Application no: H09-0646-09

Description: Details of landscaping (Condition 3 of H09-0451-07)

Location: A H Worth & Co Top Farm
Holbeach Hurn
Spalding Lincs
PE12 8LR

Amendment: Revised landscaping scheme (dwg. no. DC/116/01B)

Drawing Title TREE PLANTING

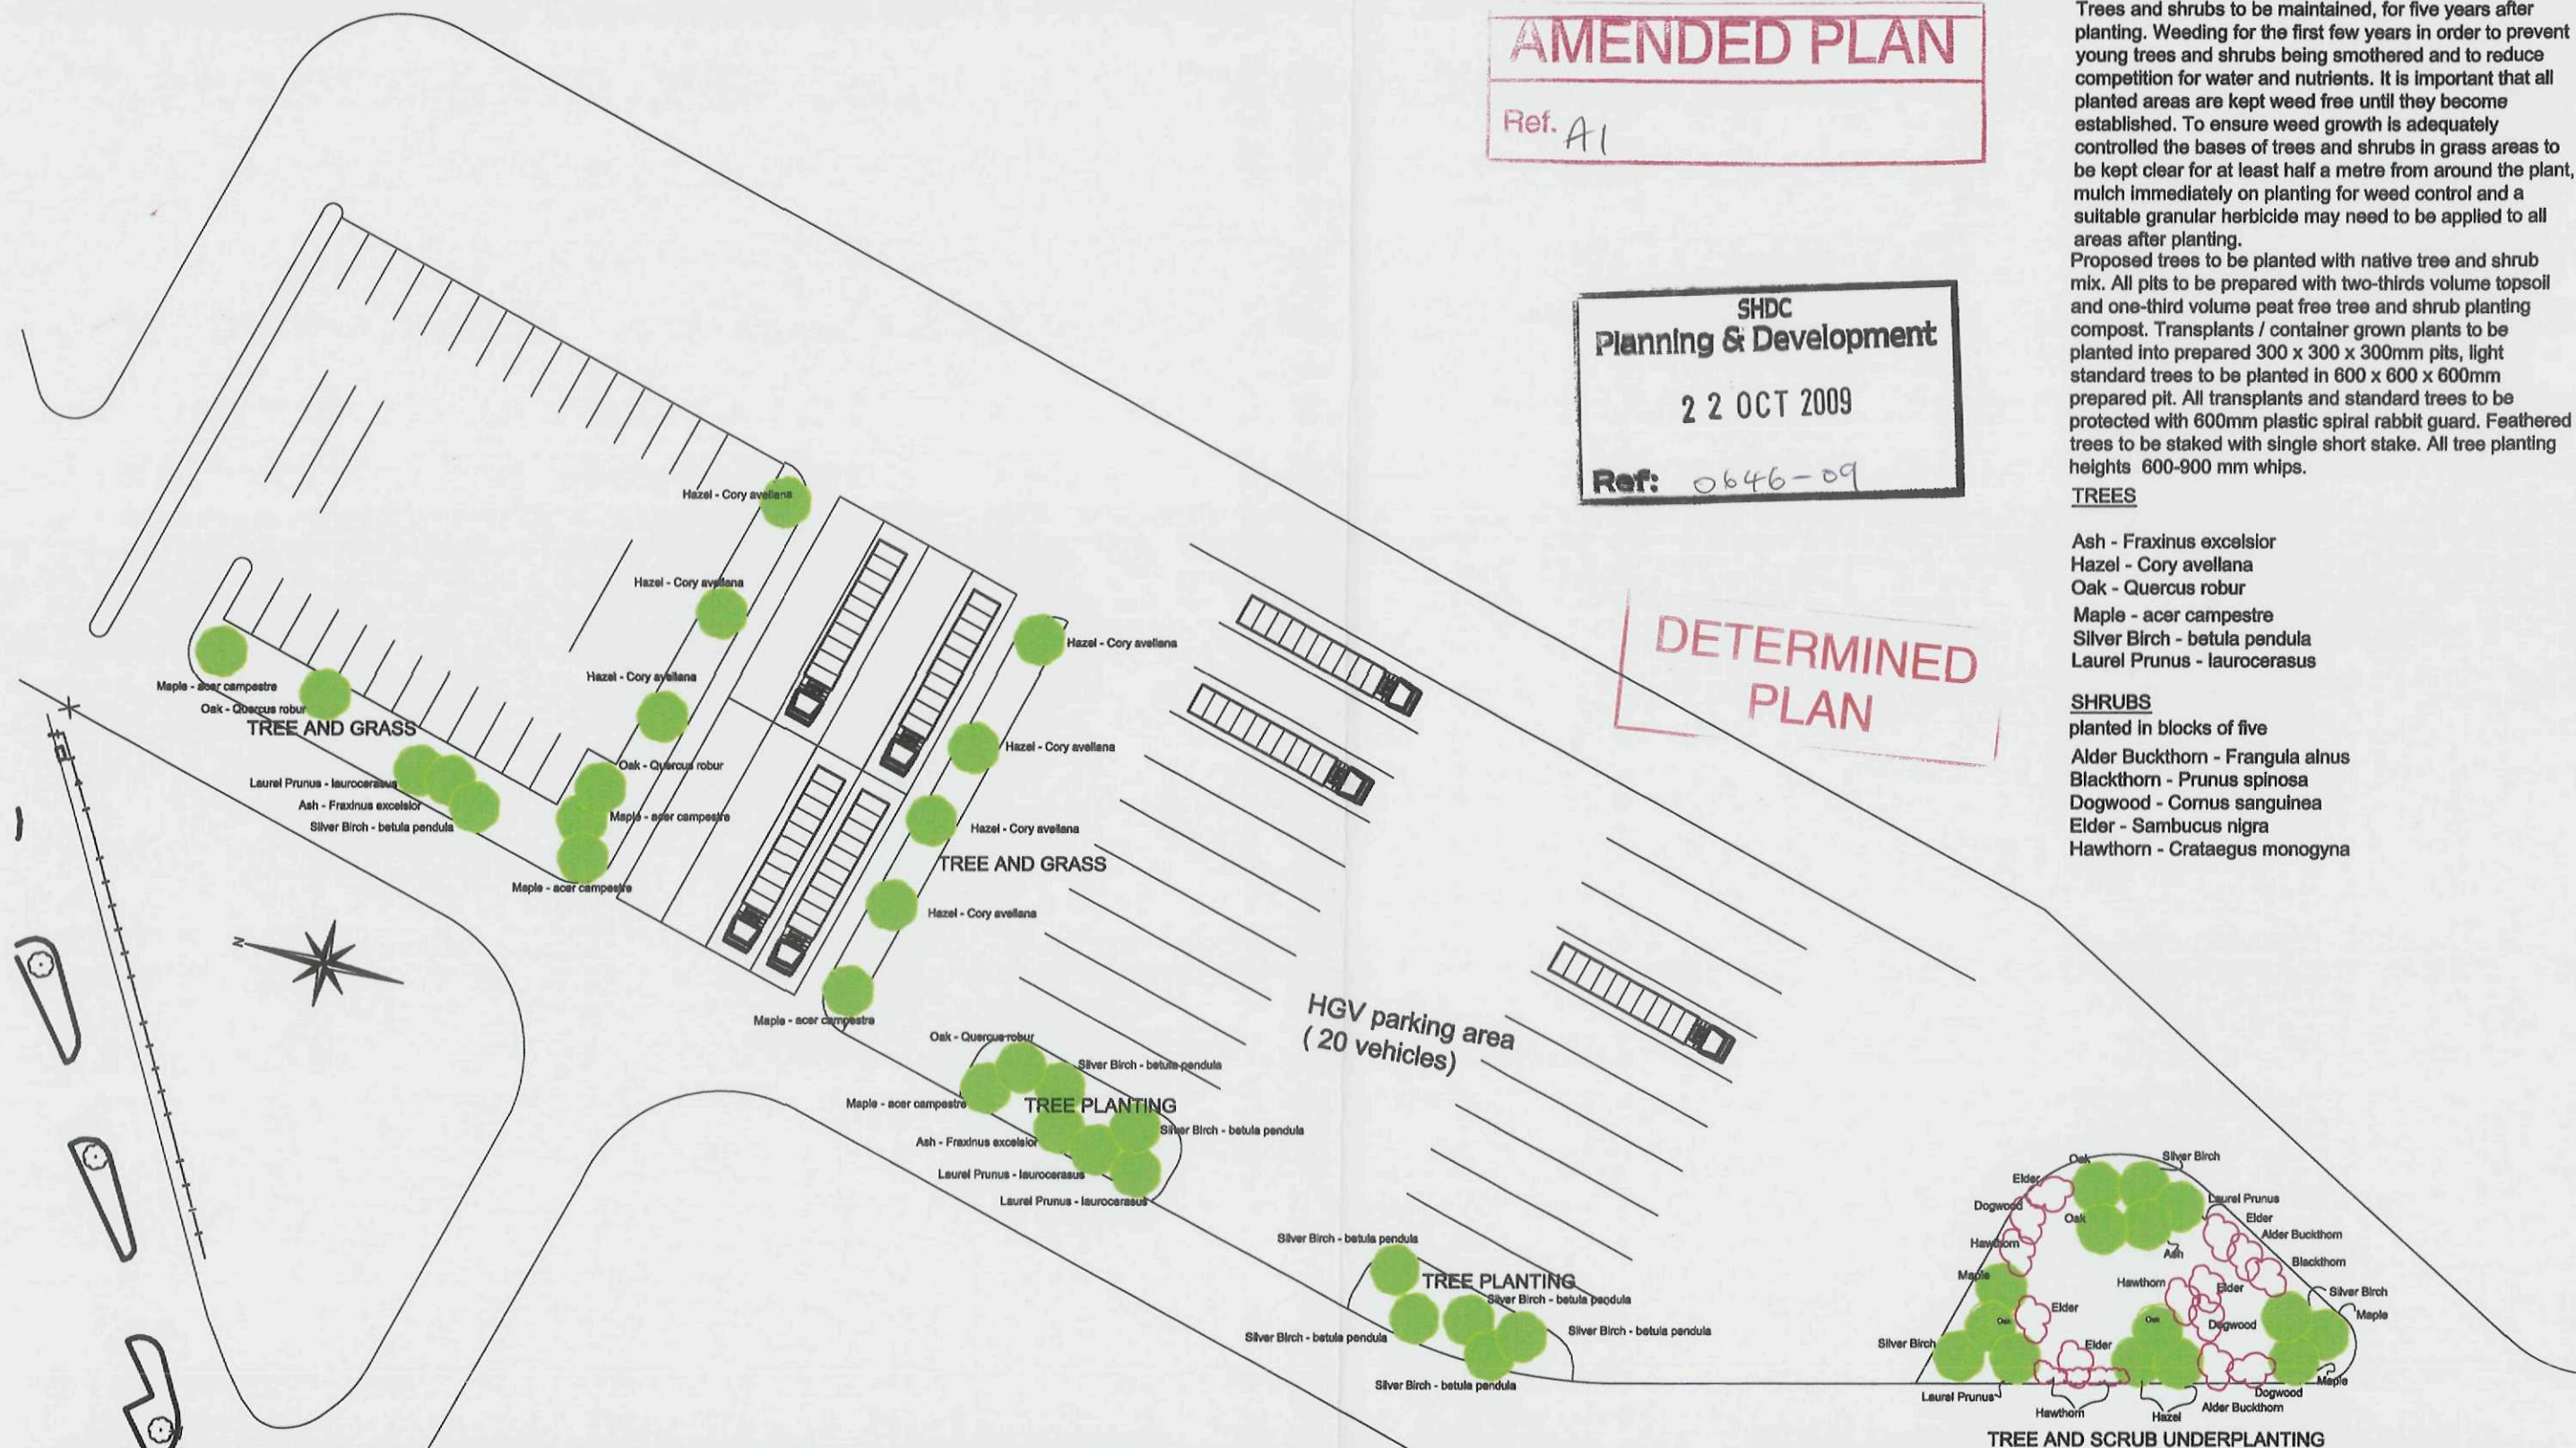
Unfortunately, however, the submitted drawing doesn't clearly show the species of each particular tree. This will be required, along with details of where the shrub planting referred to will be undertaken. Will there be any mixed native hedging around the perimeter of the parking area?

David,
Sorry for taking so long to reply , we enclose a copy of our revised landscaping scheme note there is no current proposal to hedge the perimeter.
Any further thoughts let me know
Regards
Dave
